Your Ref: OWPC23978
Our Ref: K/19/19/HH 25-06-2019
Please ask for:
Zac Denton

Two storey rear extension with a small canopy projecting the footprint to the front.
Demolition of existing living room and additional first floor for habitable use with alterations to fenestration.

Little Tangleway Middle Way Kingston Gorse East Preston

Thank you for your internet representation made on 8th August 2019 which has been recorded as '**an objection**' with the comments as follows:

Proposed Section AA

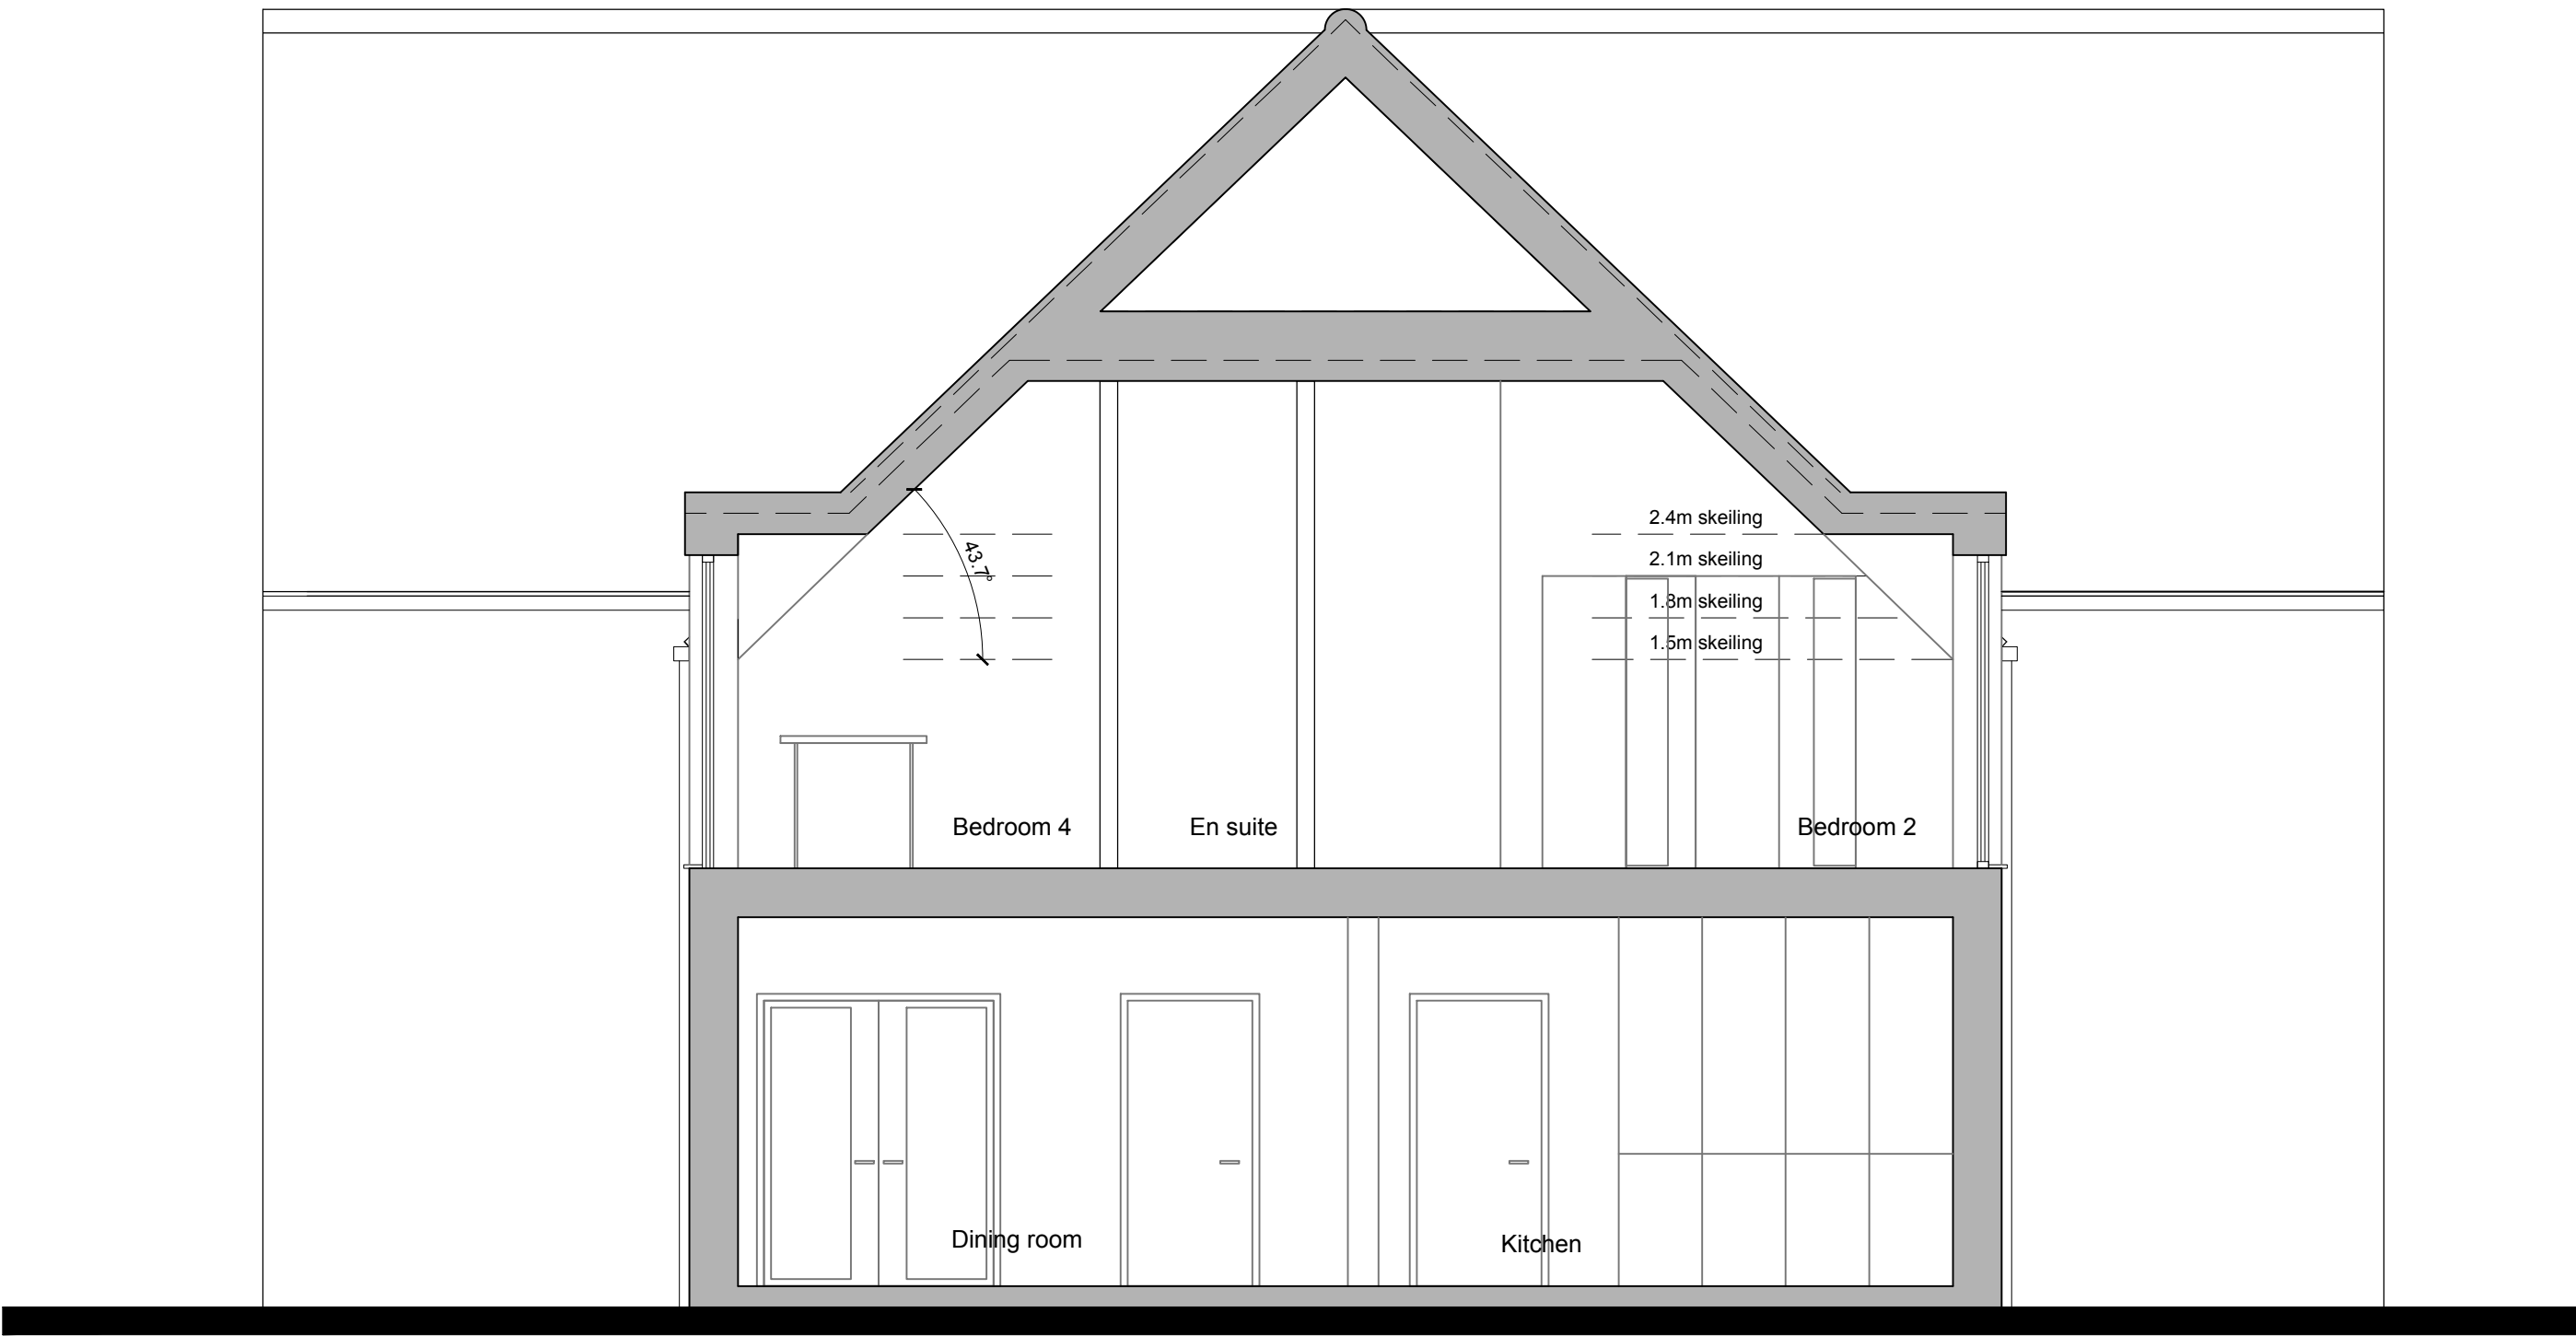
This proposal would convert a bungalow into two-storey house. This major change would create overshadowing and overlooking of the neighbouring houses. This feature of the proposal contravenes Policy D DM4 (c) of the Arun Local Plan.
